From: Laura Gibbons <Laura.Gibbons@arun.gov.uk>
Sent: 08 March 2022 10:56
To: Planning.Responses <Planning.Responses@arun.gov.uk>
Cc: David Easton <David.Easton@arun.gov.uk>
Subject: RE: Planning Consultation on: WA/22/22/DOC

Engineers Comments Regarding Condition 12

Application No: WA/22/22/DOC

Description of Works: Approval of details reserved by condition imposed under WA/22/15/OUT relating to conditions 12-surface water drainage scheme and 20 d)-details of forecourt layout, drainage and lighting.

Catchpit Detail 1200mm Ø

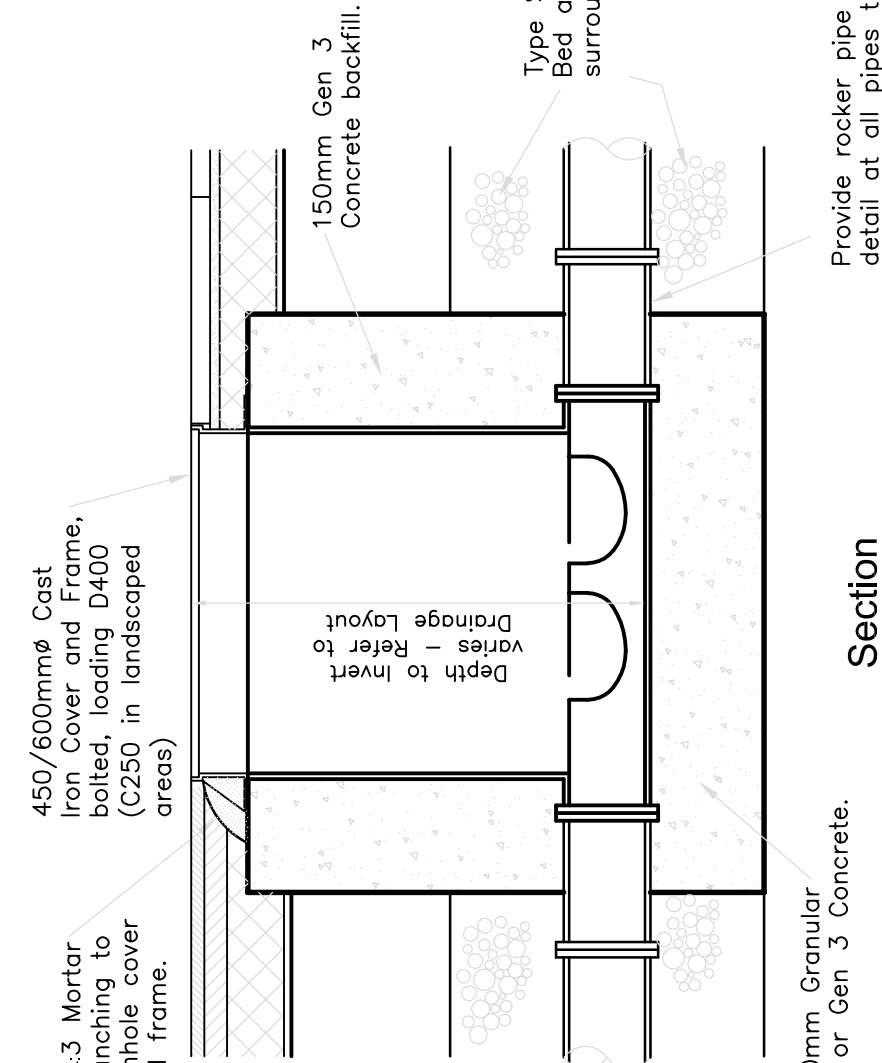
7. Dipped outlet from 1200 diameter catchpits should not be required, please detail why you believe it is required. You are passing water through sub-bases, a pond, and an interceptor prior to discharging to ground.

Rainwater Down Pipe with Gully connection to underground drainage

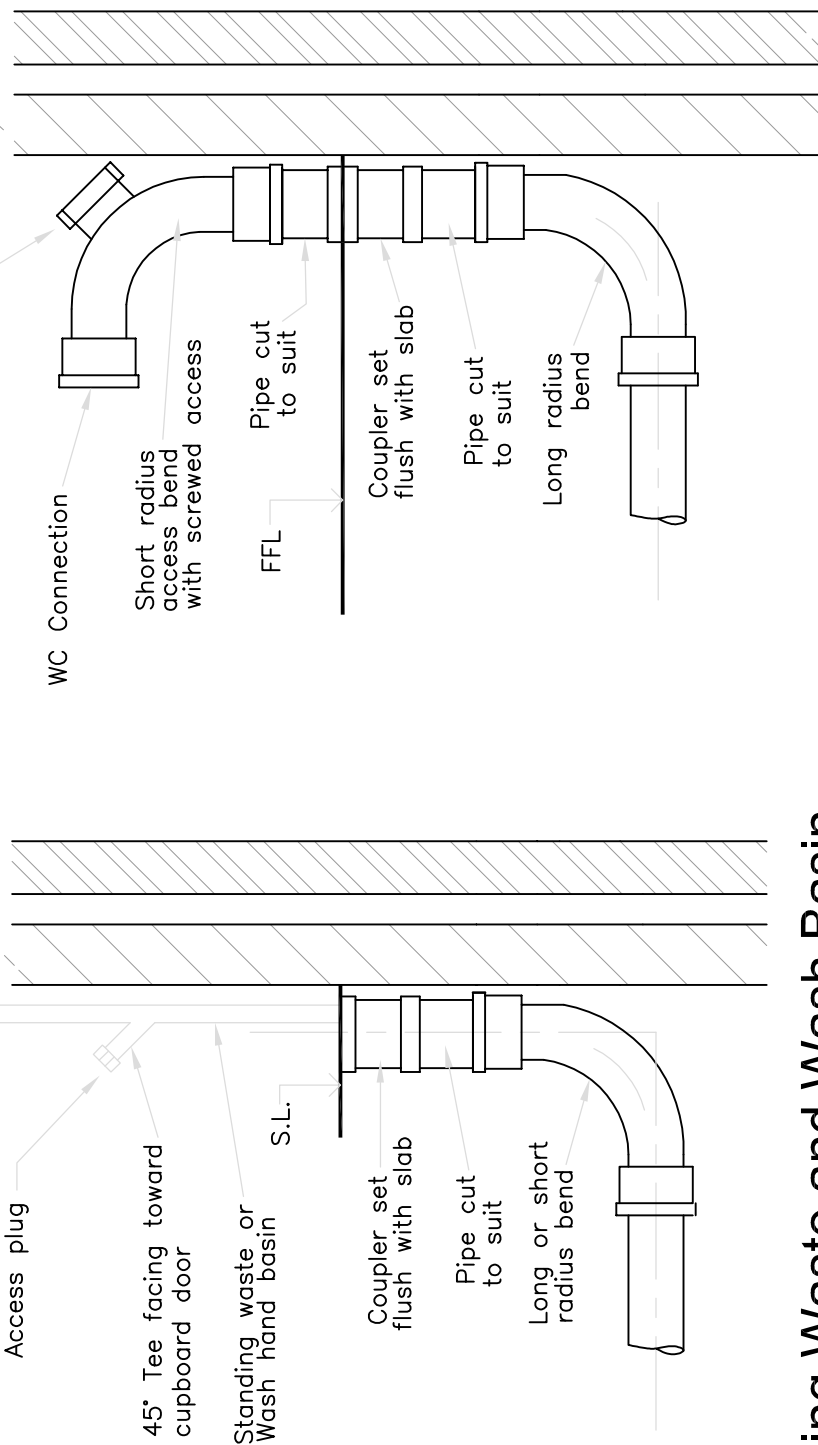
2. It is stated that gullies have been added to RWP locations. The construction detail shown of RWP discharges to permeable surface sub-bases does not currently show a silt trap. Catchpits should be provided, but as an absolute minimum bottle trap gullies should be provided.

Drg No.	Rev.
15104/21	D

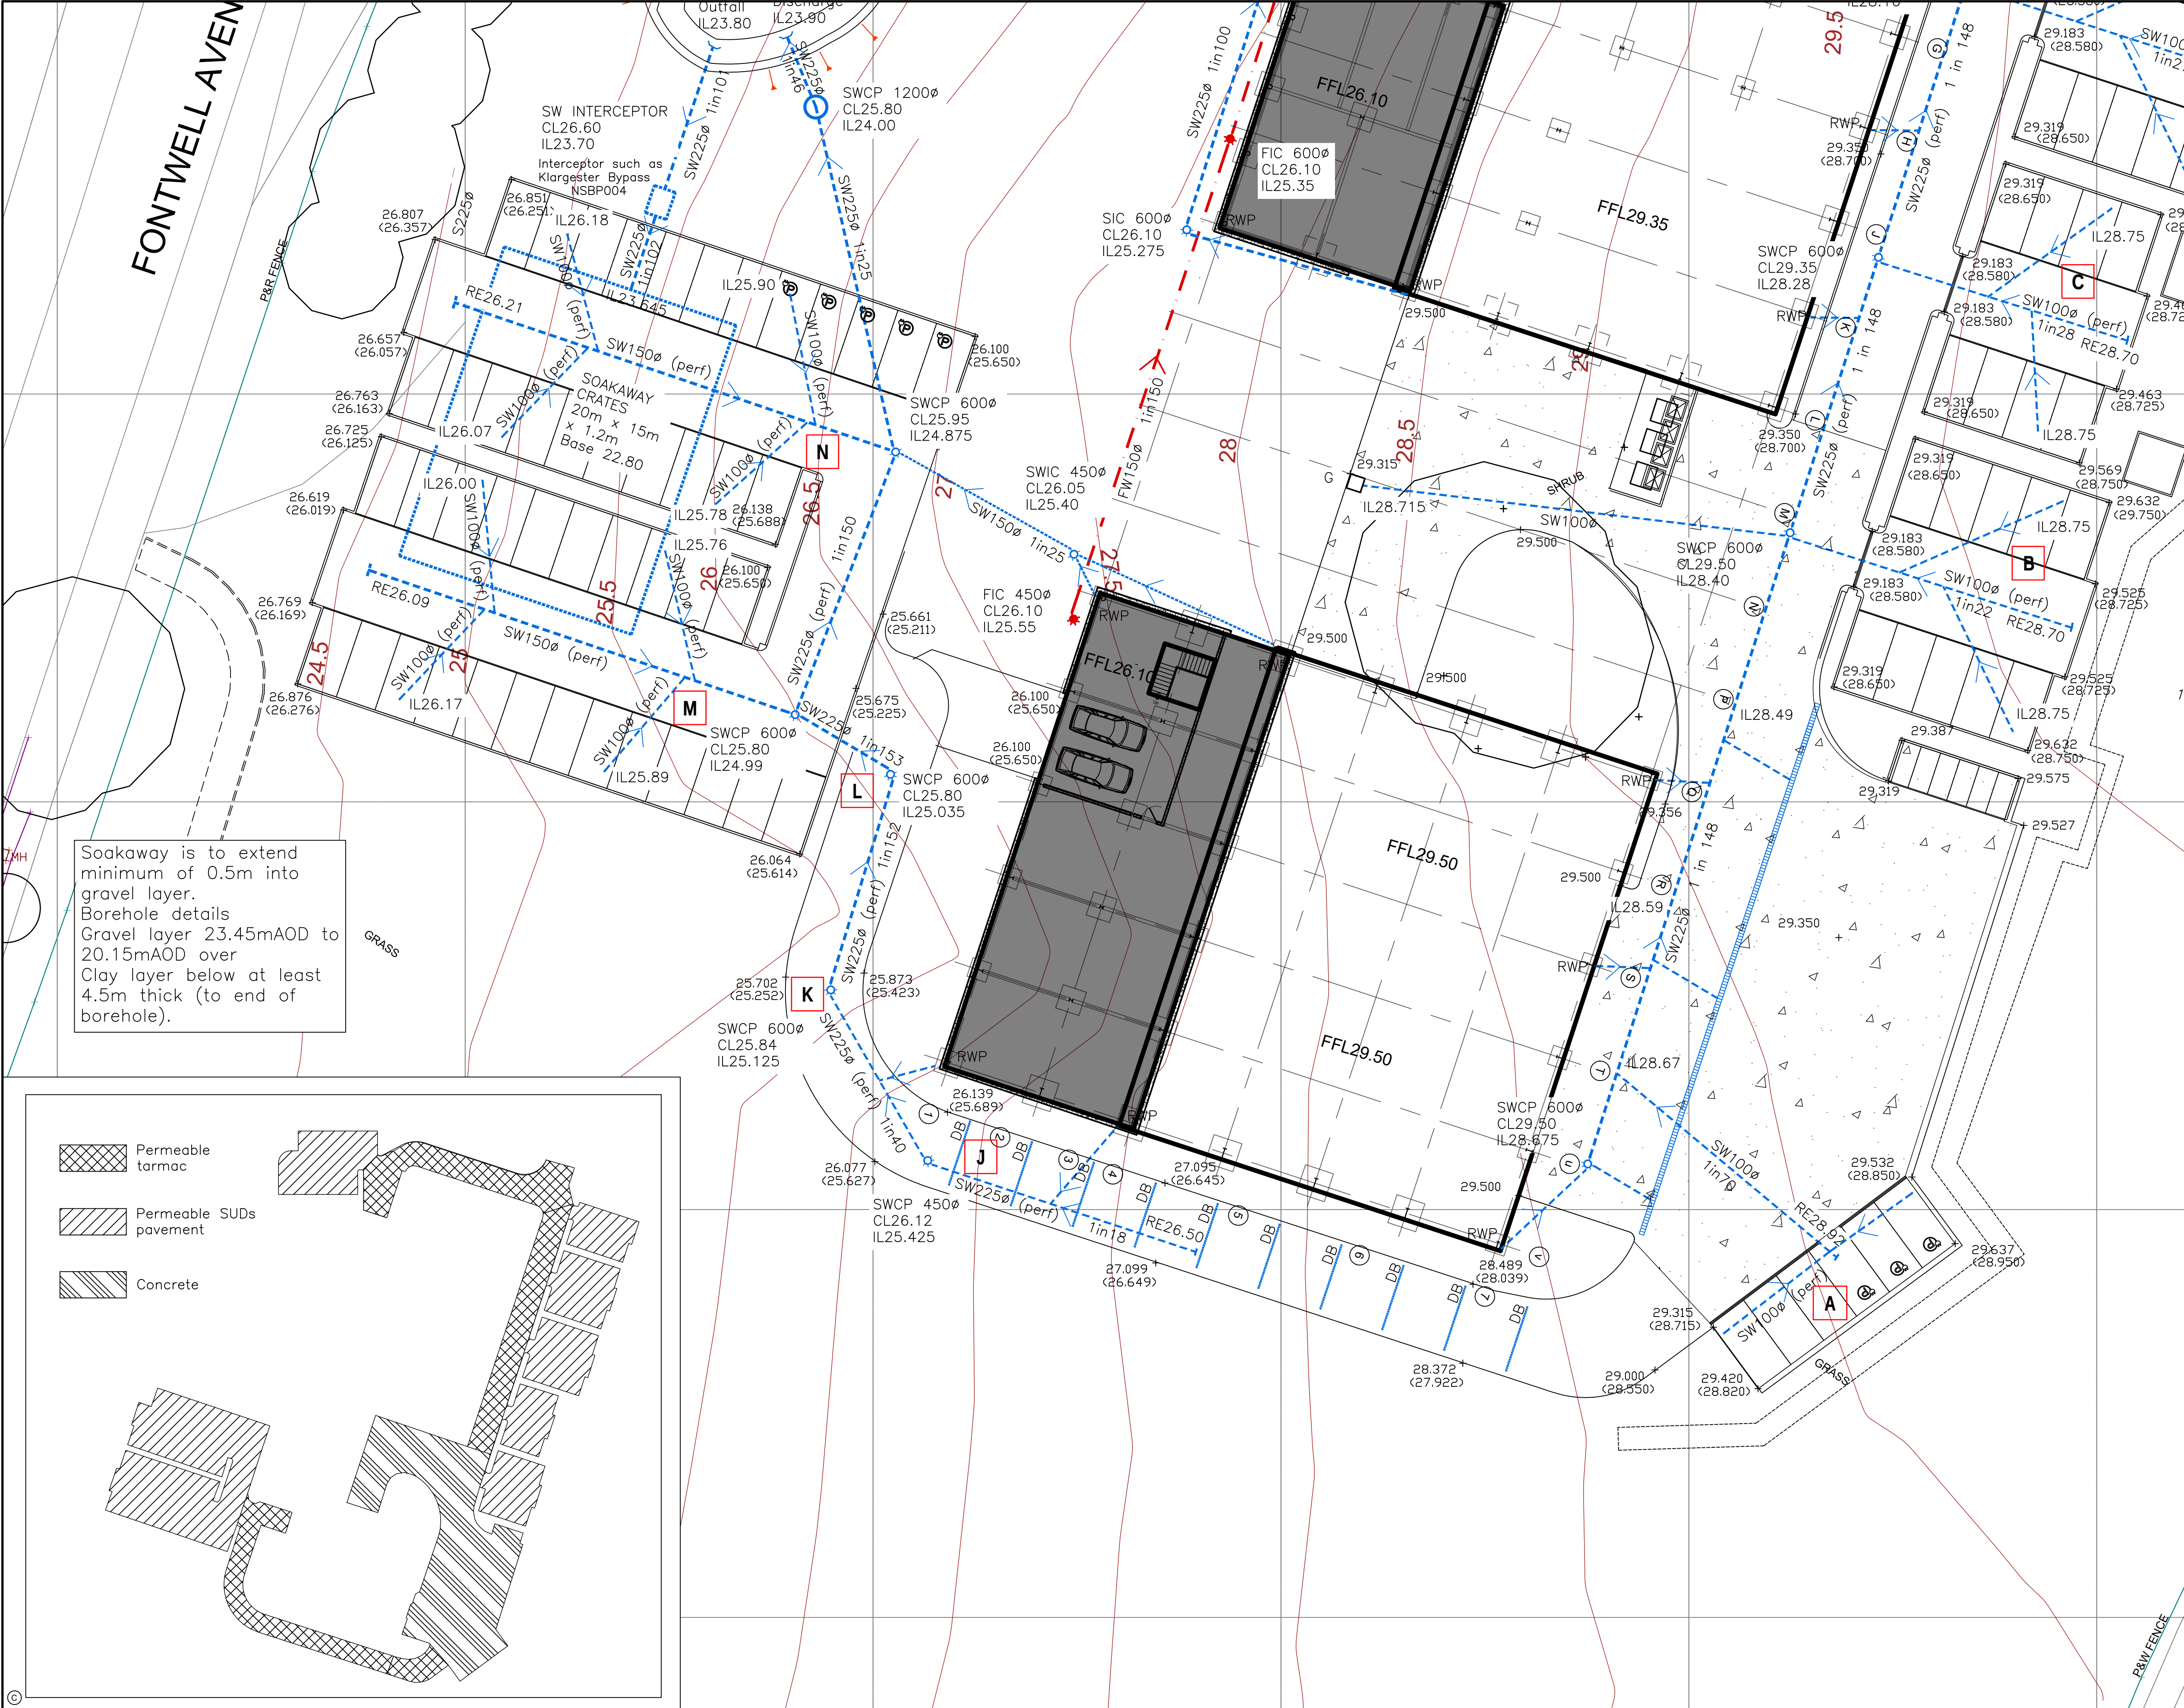
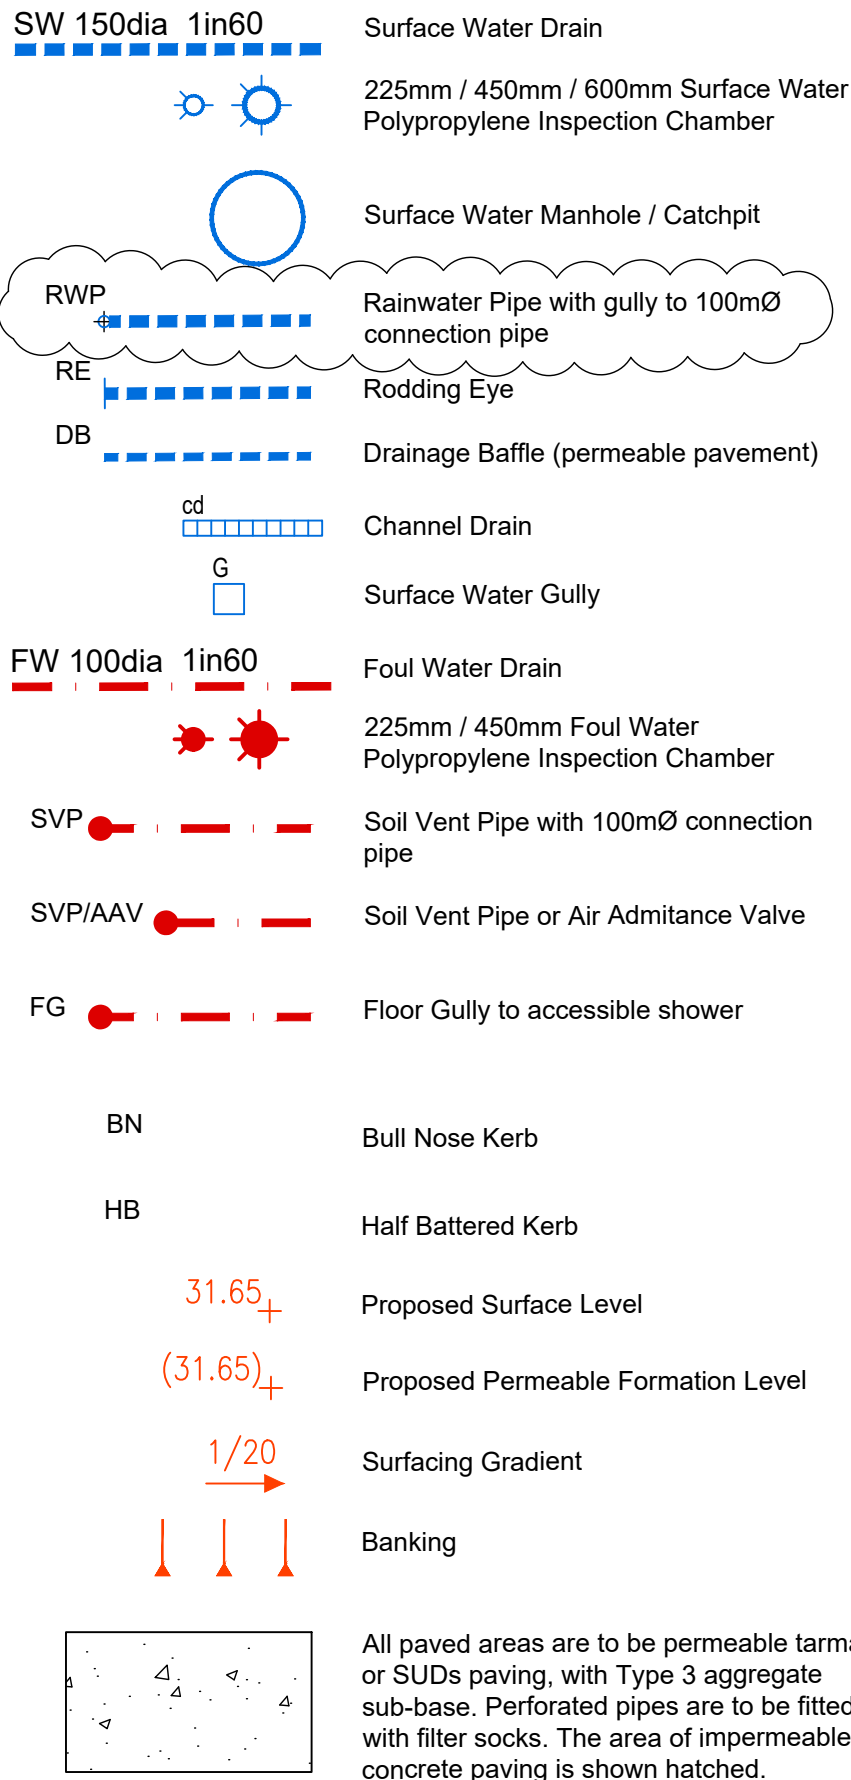
1. Permeable paving extents are not very clearly shown, a small insert layout is provided on one layout only. Permeable paving extents and types should be clearly shown on all layouts.

5. The outfall from the basin should have a 45 degree cranked grille.
6. 650mm depth of sub-base cannot be provided in permeable paving areas A and B with the finish and formation levels as currently stated.
